# BREAR ASSOCIATES

### **North Arms Pub, Mills lane, Wroxton, 19/01148/F and 19/01149/LB**

Thank you for your email of 16<sup>th</sup> August. We have taken some time to review our design and proposals to try and accommodate all comments made by neighbours, yourself and the Conservation Officer. I have answered the points raised in your email and in the Conservation Officers report below:

Drawing No
2016-34/8B

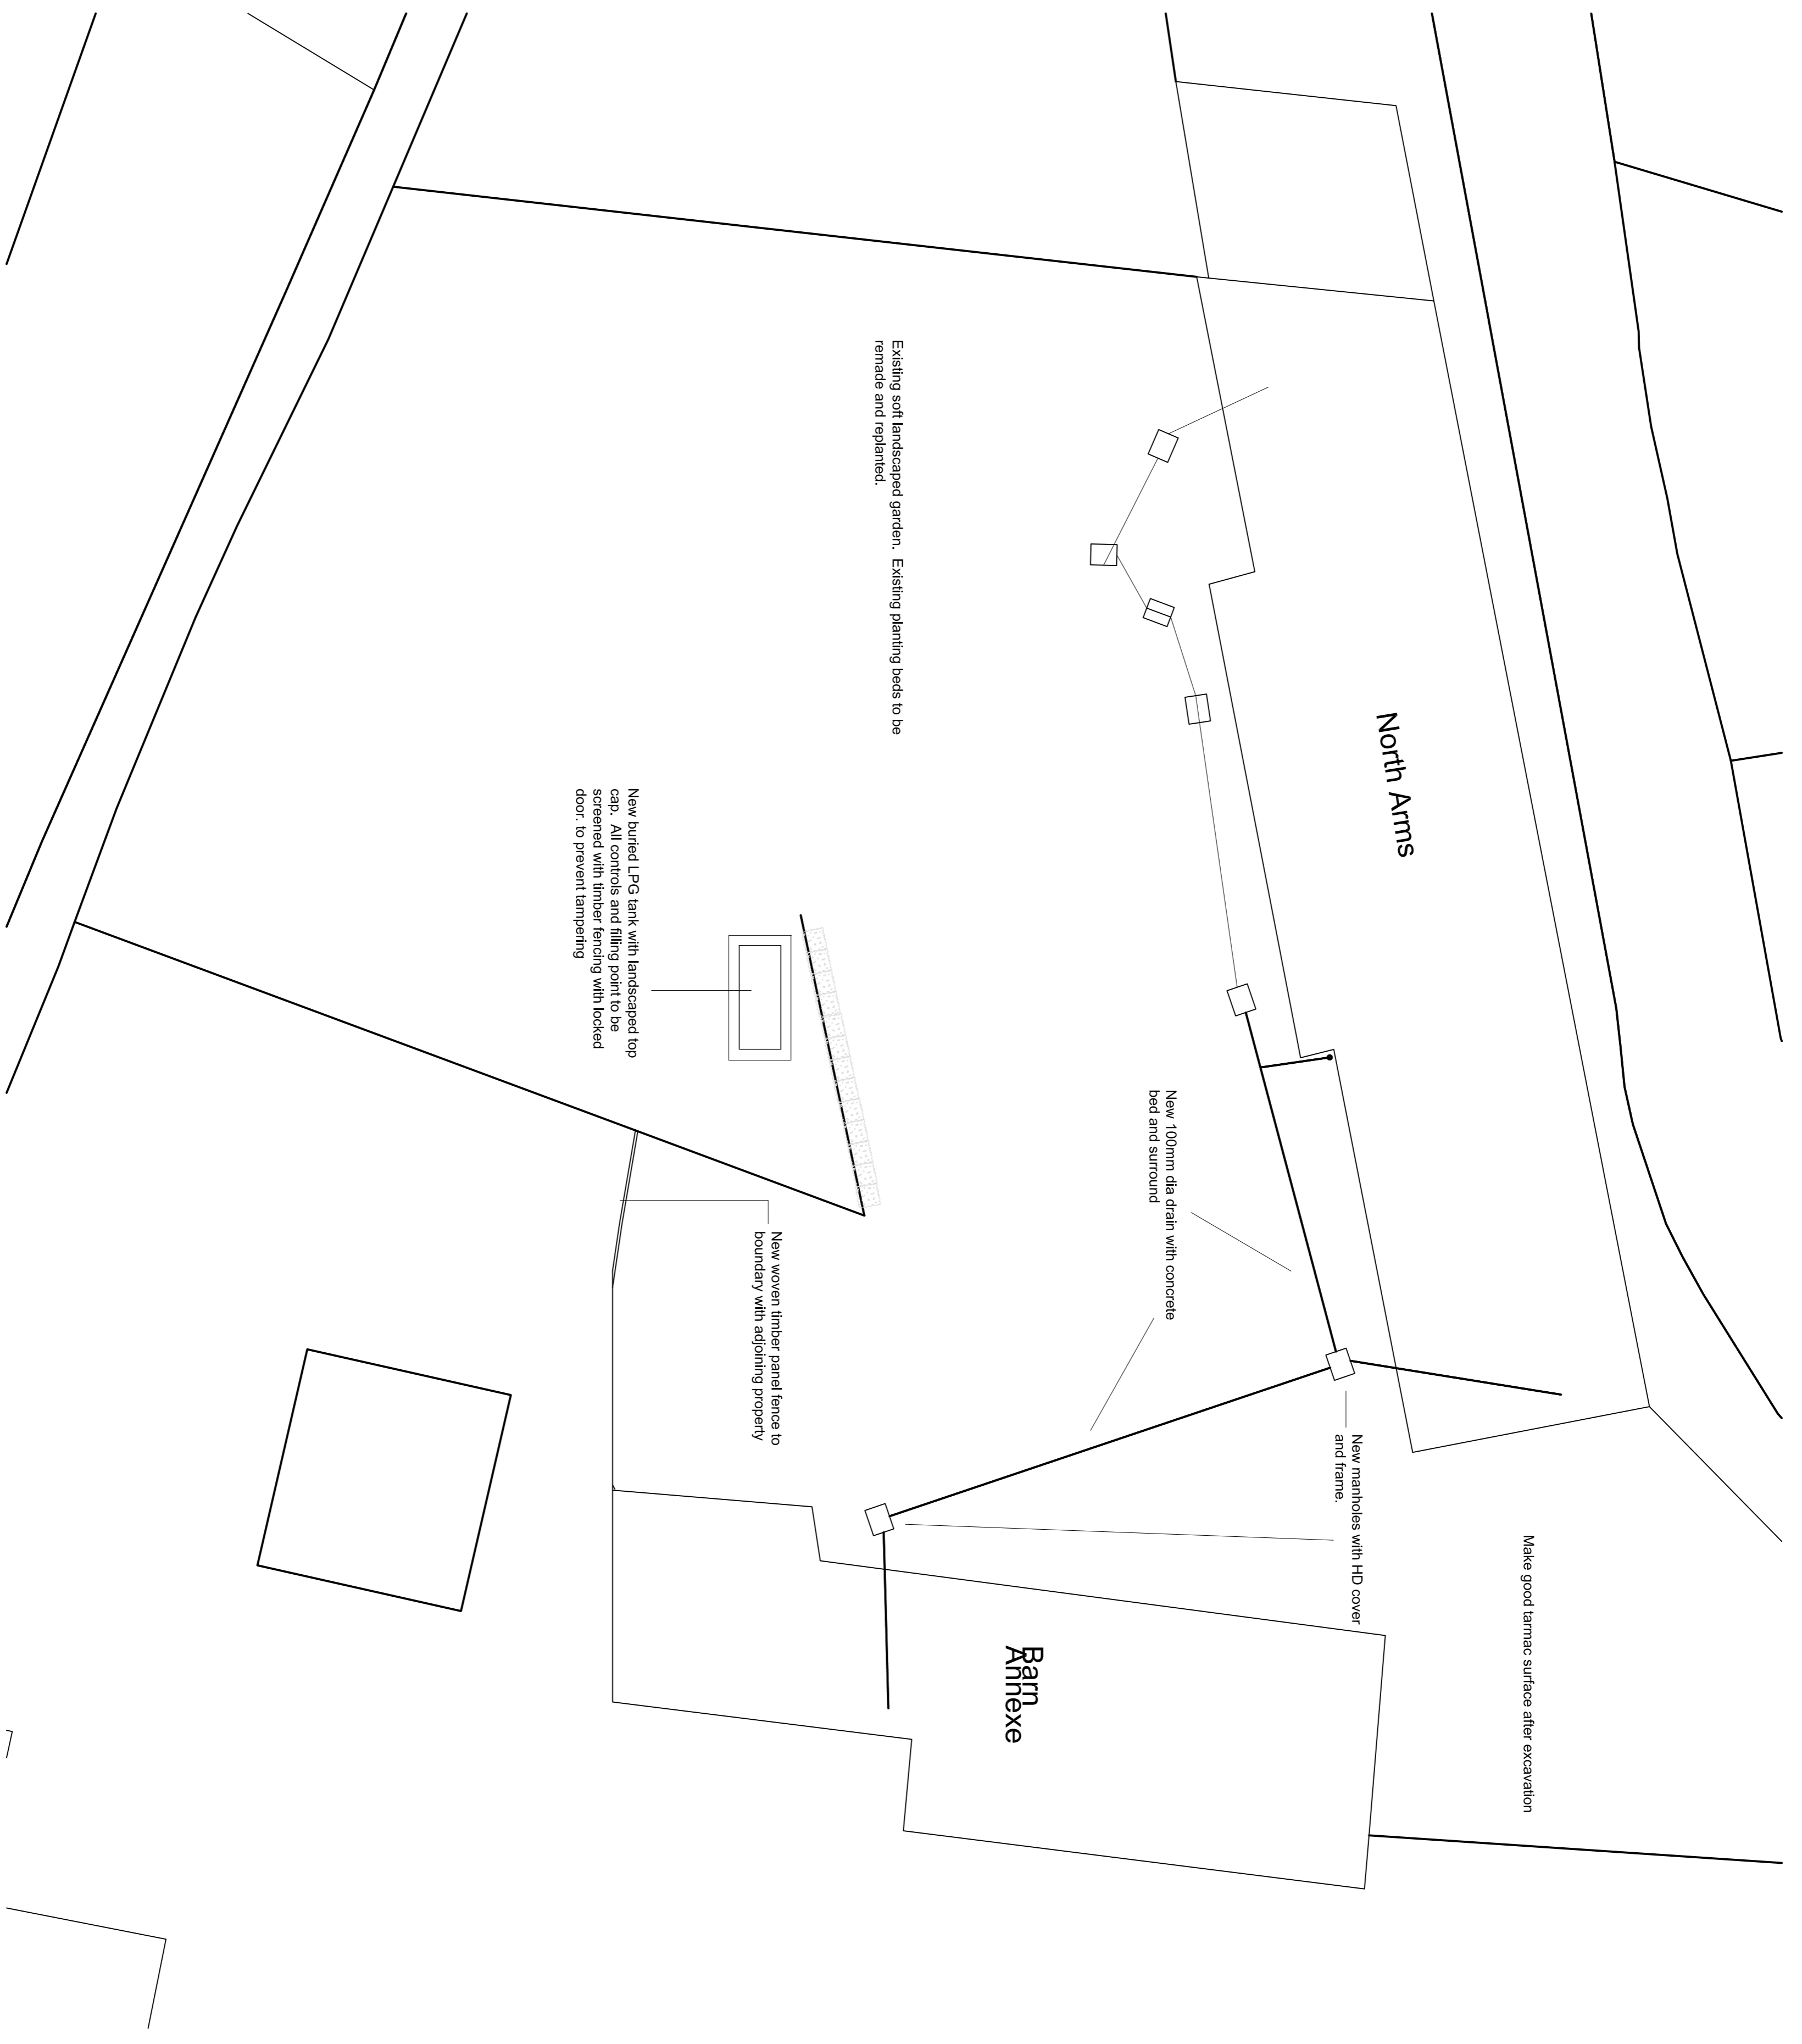
As there are no legislative requirements for a smoking shelter to be provided, we have therefore decided to remove the provision of a smoking shelter completely from the scheme. The proposed new shelter has been omitted from the scheme design. Should customers demand a shelter then this would be subject to further and separate application in the future.

No landscaping is proposed. We have revised the proposals for the short section of fencing, see attached drawings.
